To: Cherwell District Council – Planning Dept

Planning application 21/00500/OUT – Land N. of Station Rd. Hook Norton

## **OBJECTION**

Fig.3. Landscape Analysis Sketch

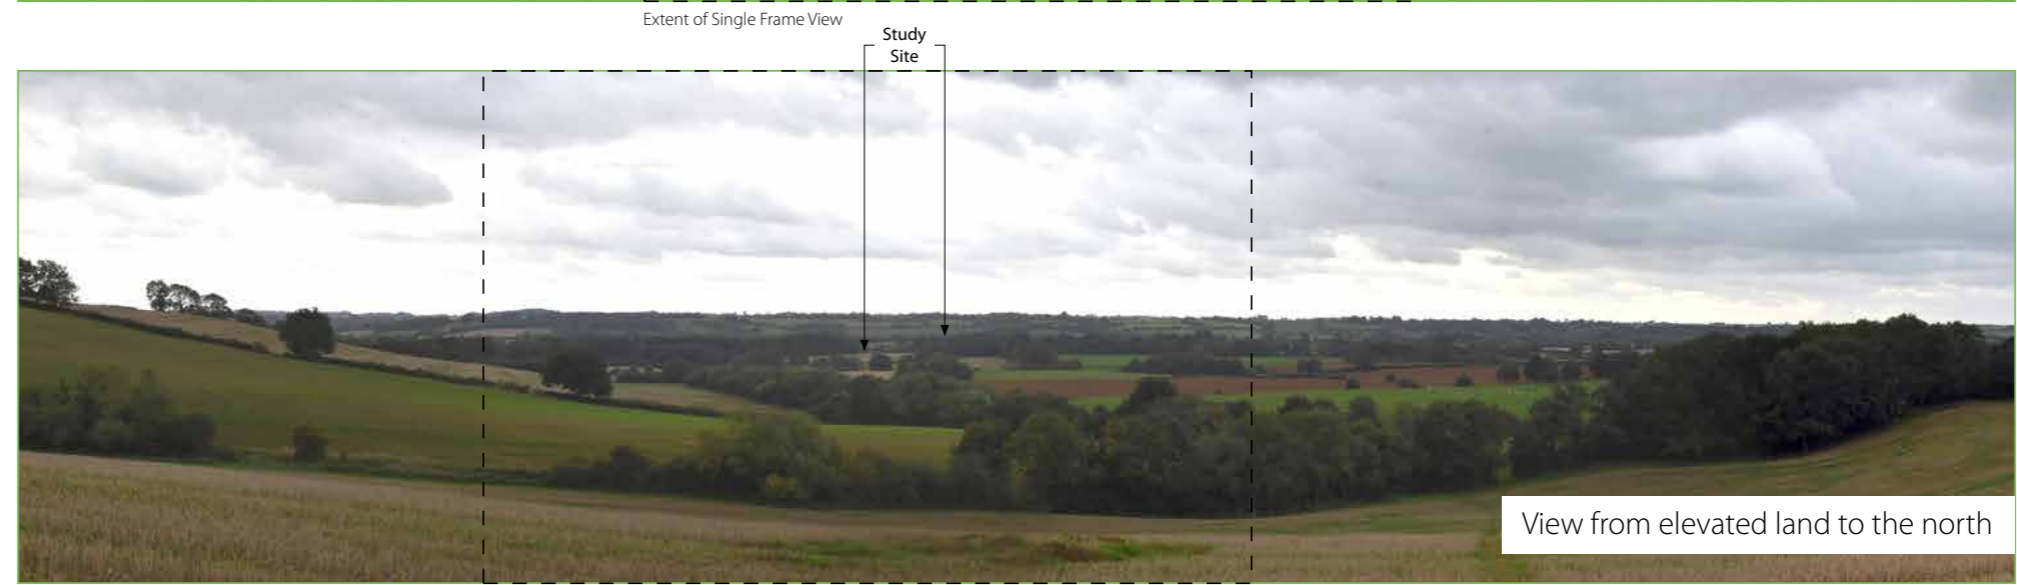
- Tree survey/arboricultural assessment
  - Statement of Community Involvement
  - PRoW statement
7. The DAS landscape analysis (Fig 3) fails to recognise the close views which are available of the site from Station Road and the PROW which runs along the northern site boundary.

8. The DAS landscape analysis (Fig 3) also appears to identify as an "opportunity" something which is simply a necessity of the scheme – the new access. A new access is required because the site cannot otherwise be used – the existing field access is outside of the site.

9. The labelling of the new access in DAS Fig 3 as something which would “maintain a rural character village gateway” therefore appears, at best, as somewhat meaningless jargon, and at worst, highly misleading

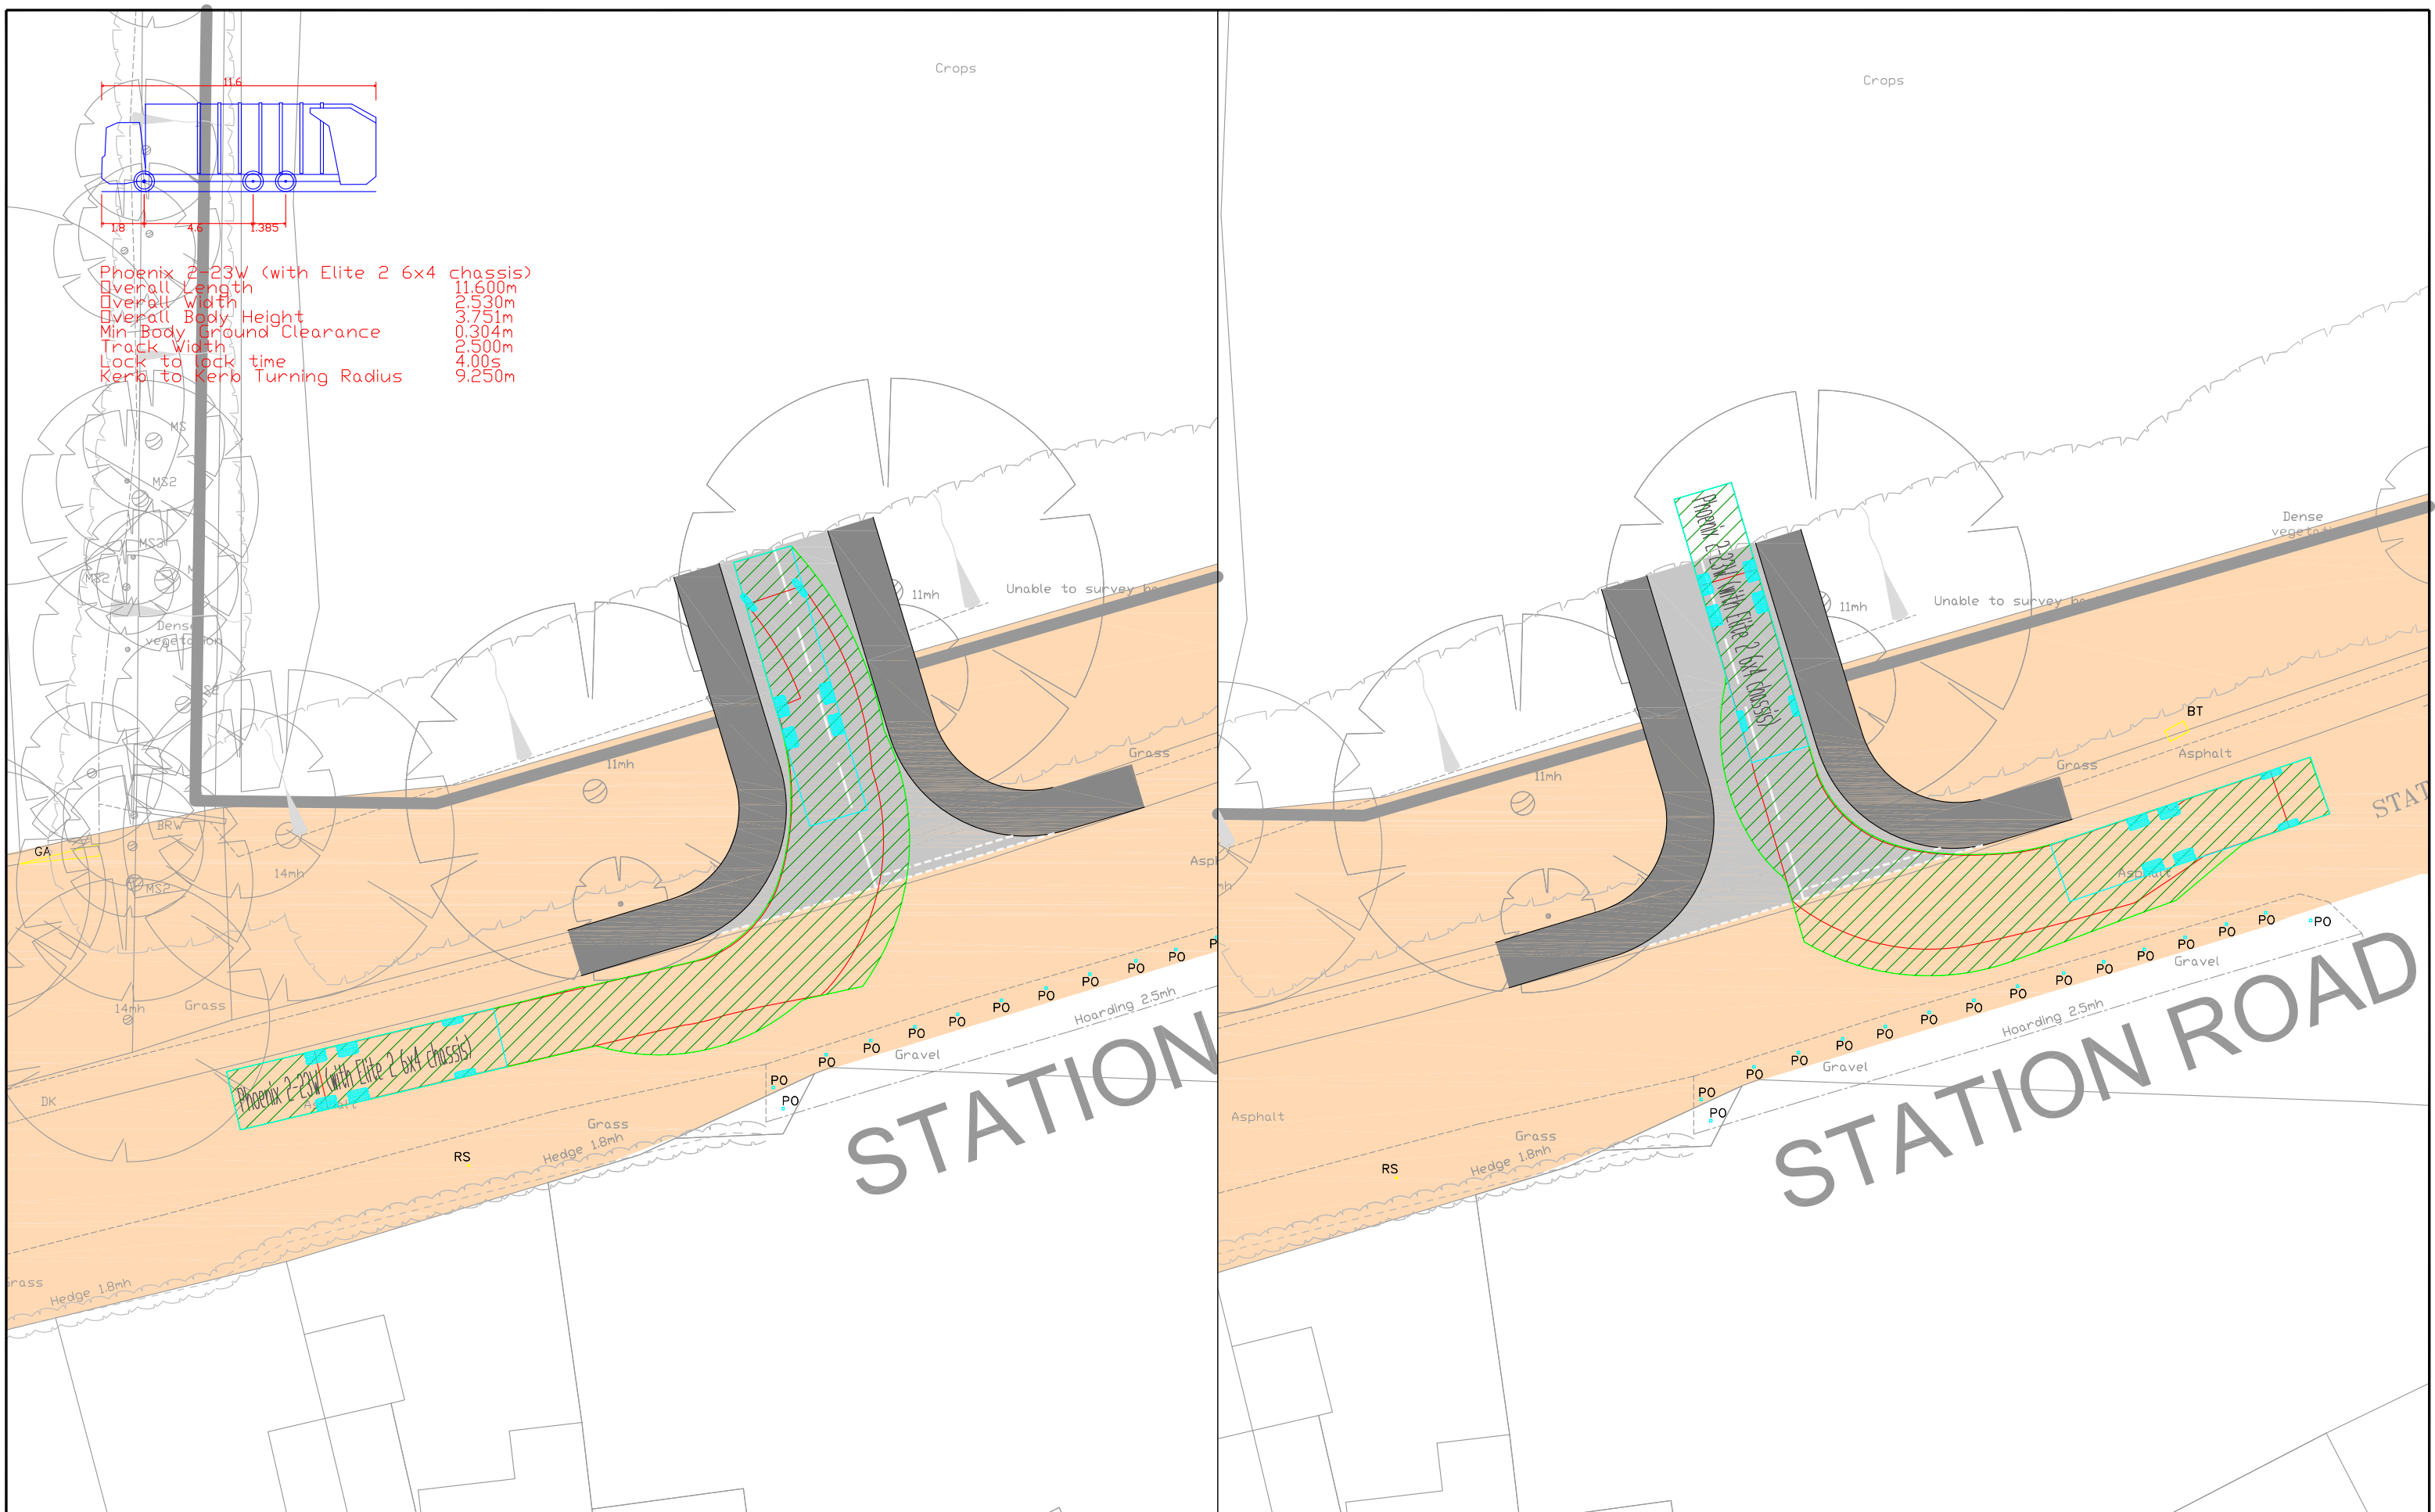
- how would the access be formed in a location where there is a steep drop from road to site level – only a simple plan is provided - no sections or detail showing how the construction would require land take in order to deal with the slope

- what effect would the proposed access have on trees and field boundary vegetation – it appears that both would be severely adversely affected by the creation of the road and by forming the proposed visibility splay

- safety of vehicles accessing and egressing together, and with cumulative effects in relation to usage of Station Road and proximity to other accesses nearby – it appears from the swept path that vehicles would have to cross to the opposite side of the road
